Advice on Environmental Impact Statement – Toga Central – SSD-33258337

Thank you for your correspondence dated 25 August 2022 inviting the City of Sydney (the City) to comment on the Environmental Impact Statement (EIS) submitted for the Toga Central development at 2-8A Lee Street, Haymarket.

The State Significant Development Application relates to Block C within the Western Gateway sub-precinct and seeks consent for adaptive re-use of the former Parcel Post building (fPPB), construction of a 45 storey tower above and public domain works at street level, lower ground level and within Henry Deane Plaza.

FIGURE 1 Landscape Masterplan - Ground Level (Arcadia November 2022).

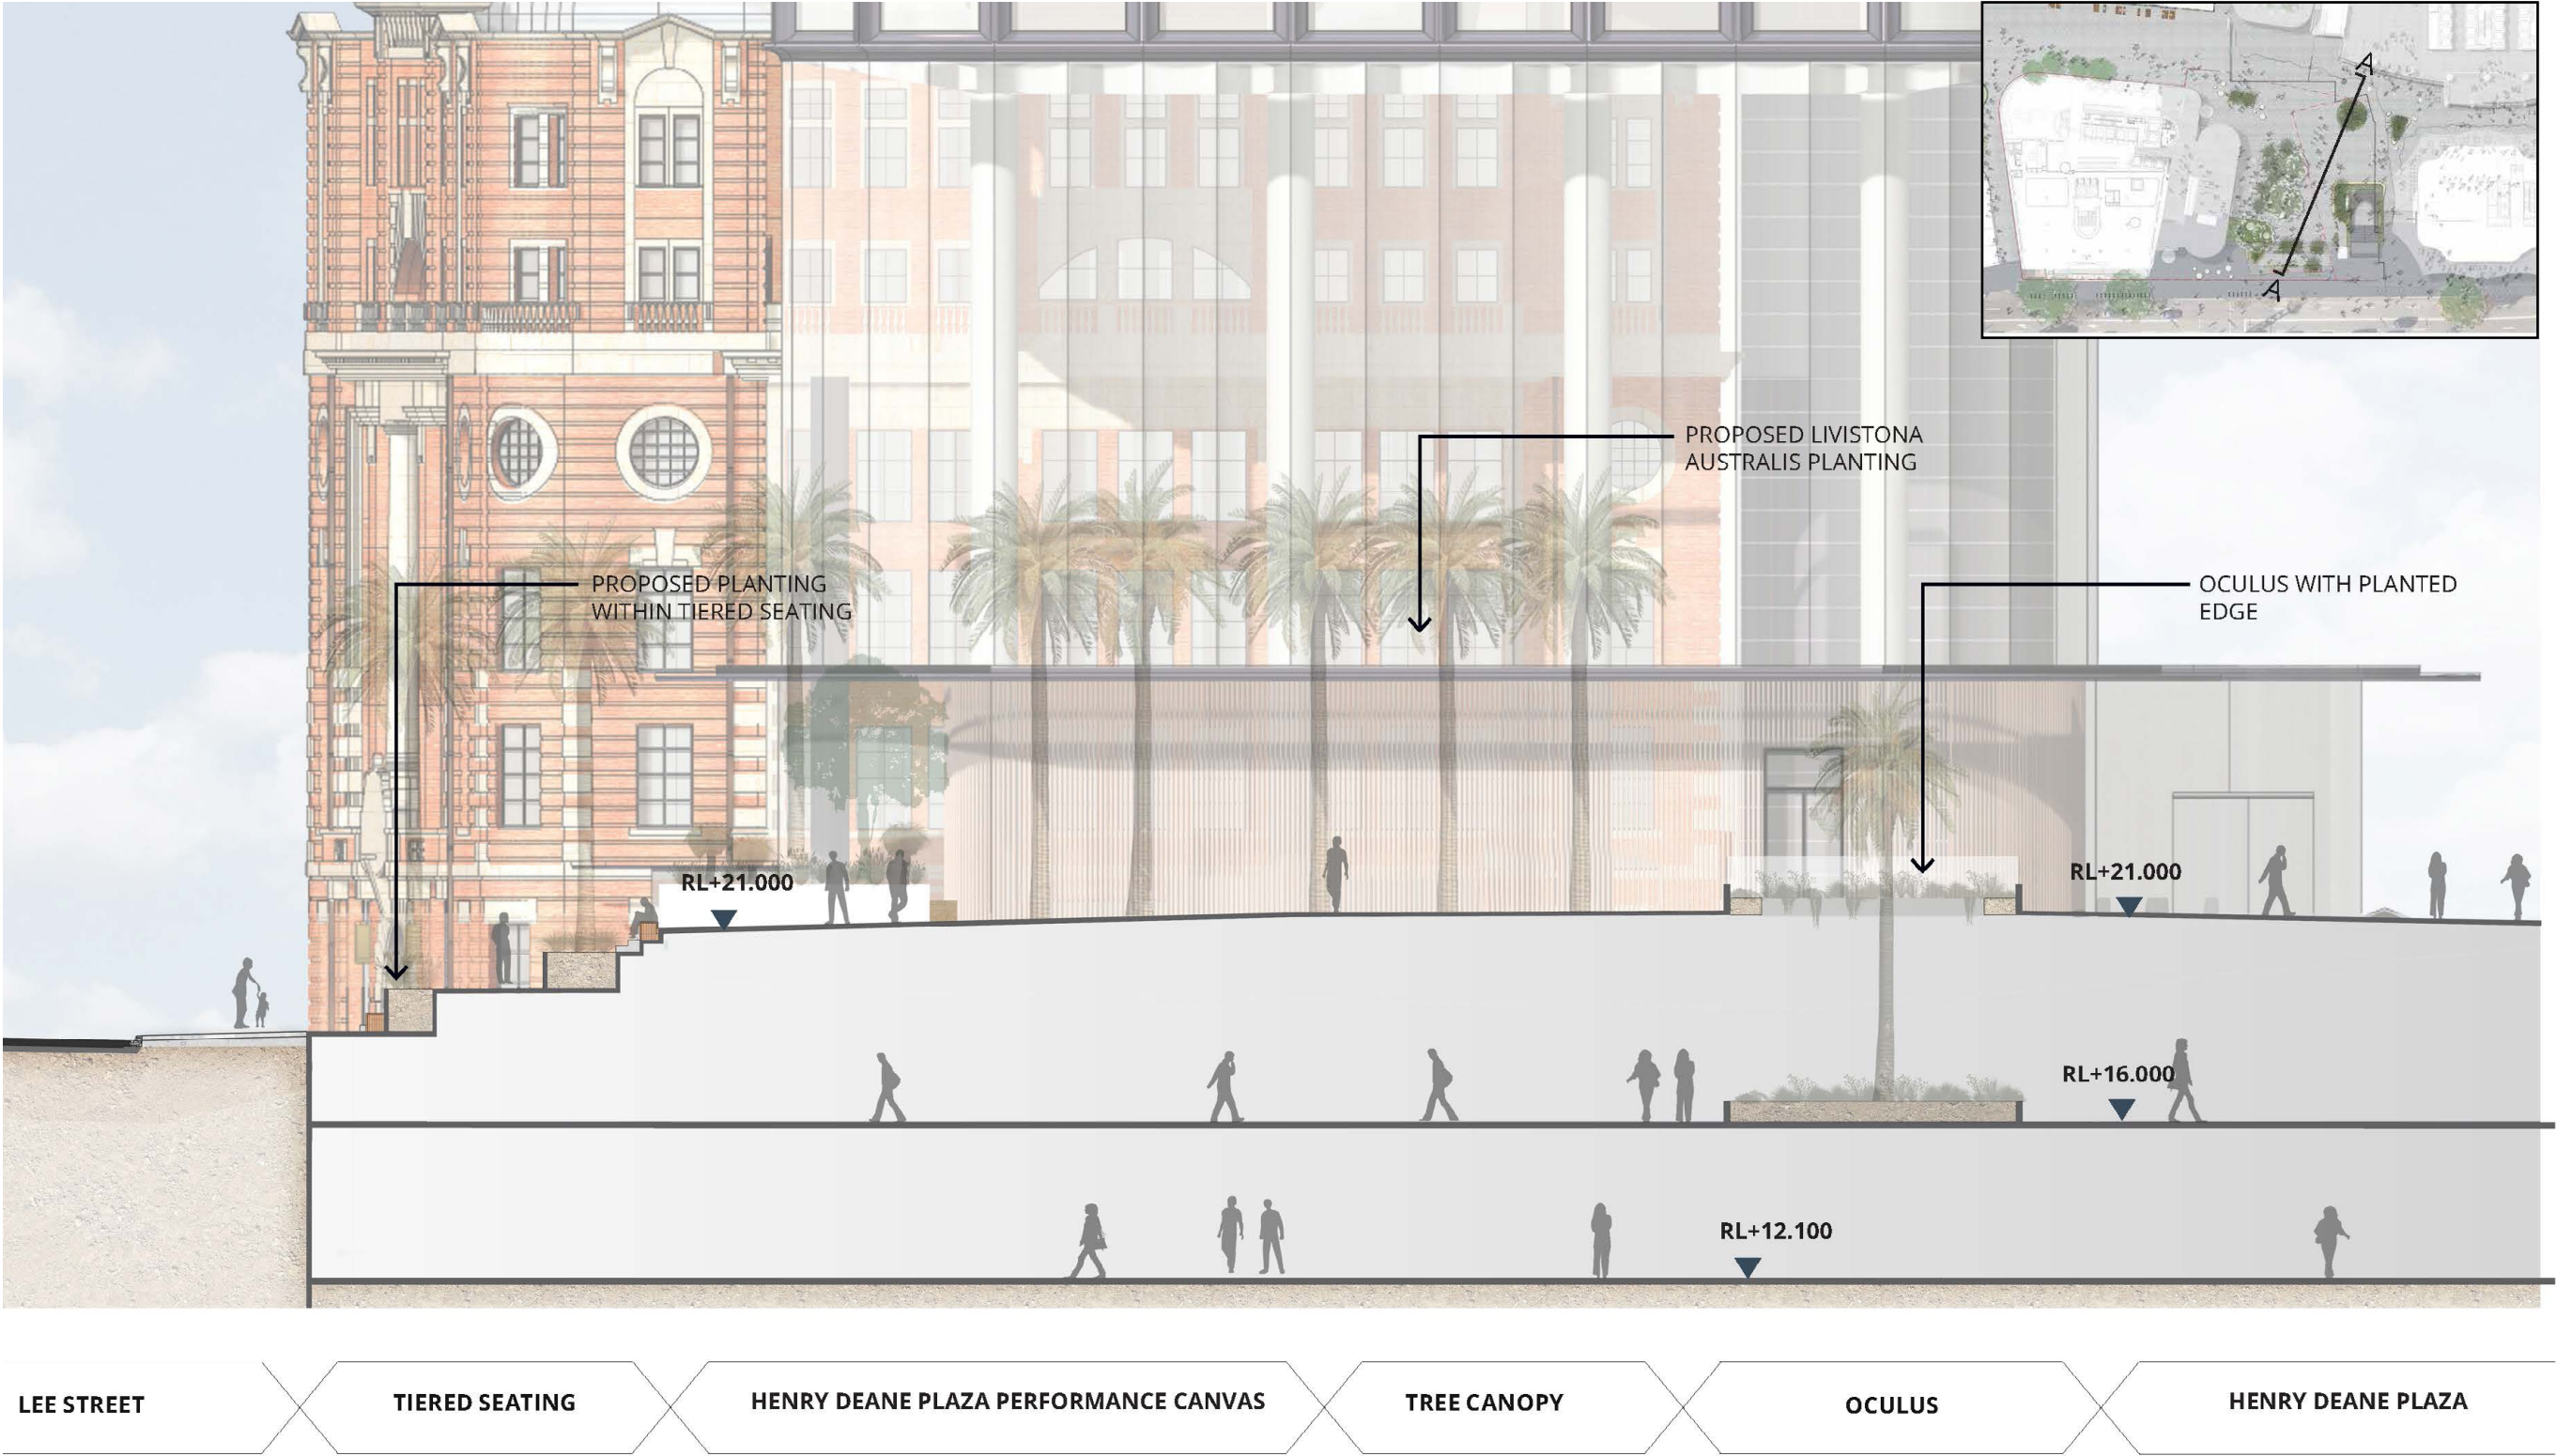
The documents accompanying the EIS identify the east-west connection between Lee Street and the over station development as a key people movement corridor. However, the frontage along Lee Street is defined by a large extent of stairs, which **only caters for able bodied people**. This is outlined in Figure 1 below.

The design must be amended to provide allowance for a ramp to ensure an equitable and universal access route at this key east-west movement corridor and also provide clear wayfinding from Lee Street to the public space above.

Geometry of primary forms - The geometry of the primary forms, including the stairs and lift structures, is aligned to Lee Street and its orthogonal form does not relate to any of the adjacent buildings. The geometry should be revised to be less formal and attempt to reconcile the varying geometries of the buildings which form the enclosure of the plaza.

Geometry of the stairs - The geometry of the stairs from Lee Street up to RL 21 do not respond to pedestrian desire lines and peak flow. The principal issue is the width and generosity of the stairs along Lee Street and the protrusion/ break caused by the vertical elements (walls enclosing the BOH functions of Basement level 1). These vertical walls create dead ends at both the upper

(RL 21) and lower (RL 17) levels. The extent of floor space on the RL 16 level is excessive and contributes to this issue. Redesigning the stairs to be in an east-west direction (and the inclusion of a ramp as noted above) would improve the visibility of the upper level and offer a clear sightline to the future over station development connection.

Materiality - The paving treatment between adjoining sites must be resolved to ensure consistency. The Landscape and Public Domain report is not specific regarding the proposed materials for the public domain. The report provides a choice of 15 different granite paving options and 3 different wall options (brick, granite and concrete). The use of red brick should be reconsidered to avoid using the same material as the fPPB.

- The proposal must be amended to provide allowance for a ramp on the Lee Street frontage and include clear wayfinding. Any amended design must meet the requirements of the City's Inclusive and Accessible Public Domain Guidelines.

- The extent of the BOH at RL 16 from the Lee Street entry should be reduced to elongate the stair further east and to allow inclusion of a ramp. This will increase views into the plaza and make the stair more generous and easier to access.
- The hard vertical edges should be reduced to be no more than 1 metre in height and landscaped terraces and informal seating areas should be added instead.
- The visual aperture from Lee Street up to the plaza level must be increased through the removal of vertical walls.
- The geometry should be relaxed to respond to the varying building and street alignments within the context.
- A direct line of sight is to be created to the future OSD walkway.
- The materiality should be reconsidered to avoid using the same material as the heritage item.
- Materiality of the public domain should be clarified.
